From: Kerry Simmons [REDACTED]
Sent: 04 June 2019 16:29
To: Natalie McKellar; Zac Denton
Cc: Paul White; Juan Baeza
Subject: RE: Response To Application Number CM/13/19/RES at Mistletoe Farm Horsemere Green Lane

Subject: RE: Response To Application Number CM/13/19/RES at Mistletoe Farm Horsemere Green Lane

Drawing Title				
Engineering Details Drainage Strategy (with Ditch)				
Drawn	Checked	Scales	Paper Size	Date
KN		1:250	A1	07.19
Job No.	Drawing No.	Revision		
ES1820	602-04	C

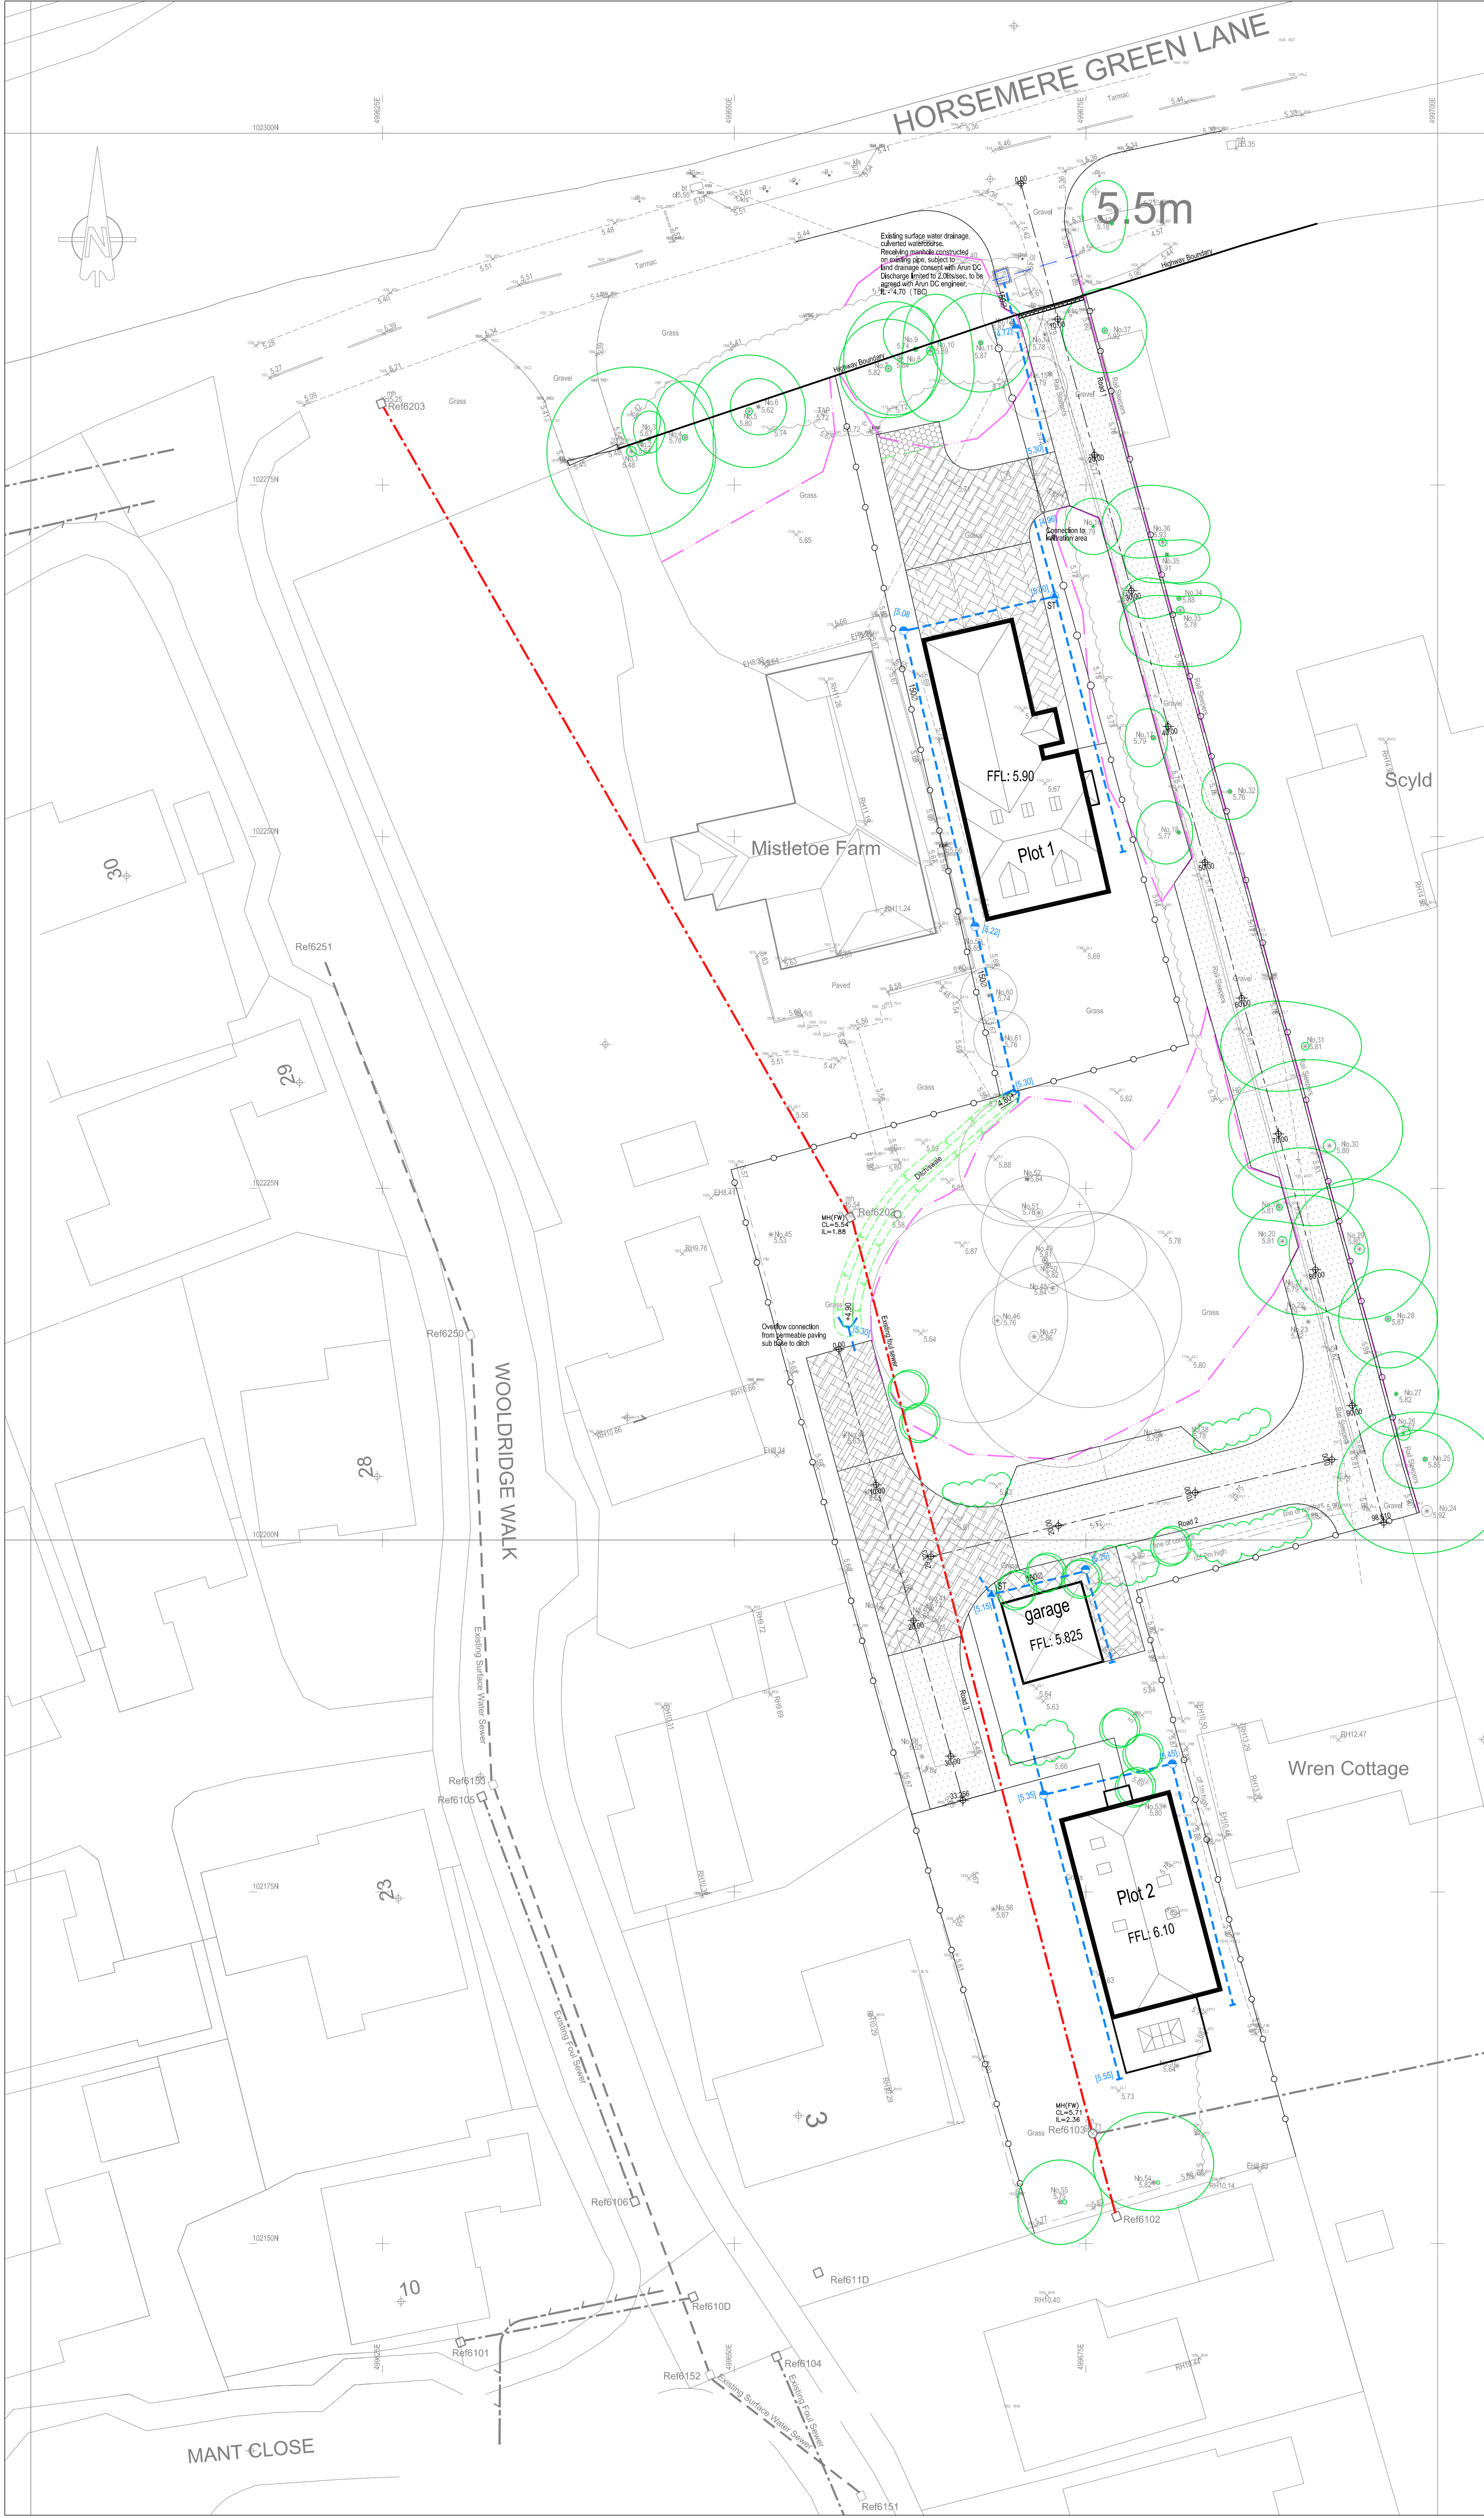
"As discussed there is inadequate information provided to demonstrate that the site can be drained. To support the proposed locations of soakaways I require infiltration testing results to be submitted. As stated previously even if infiltration testing is completed now this will at least indicate if infiltration is feasible and soakaways provisionally sized. Further drainage design can then be conditioned to enable winter testing and detailed design to be completed."

Before agreeing a layout, it needs to be established that surface water drainage is achievable. The Engineers are currently unconvinced that the layout provides sufficient space for surface water drainage.
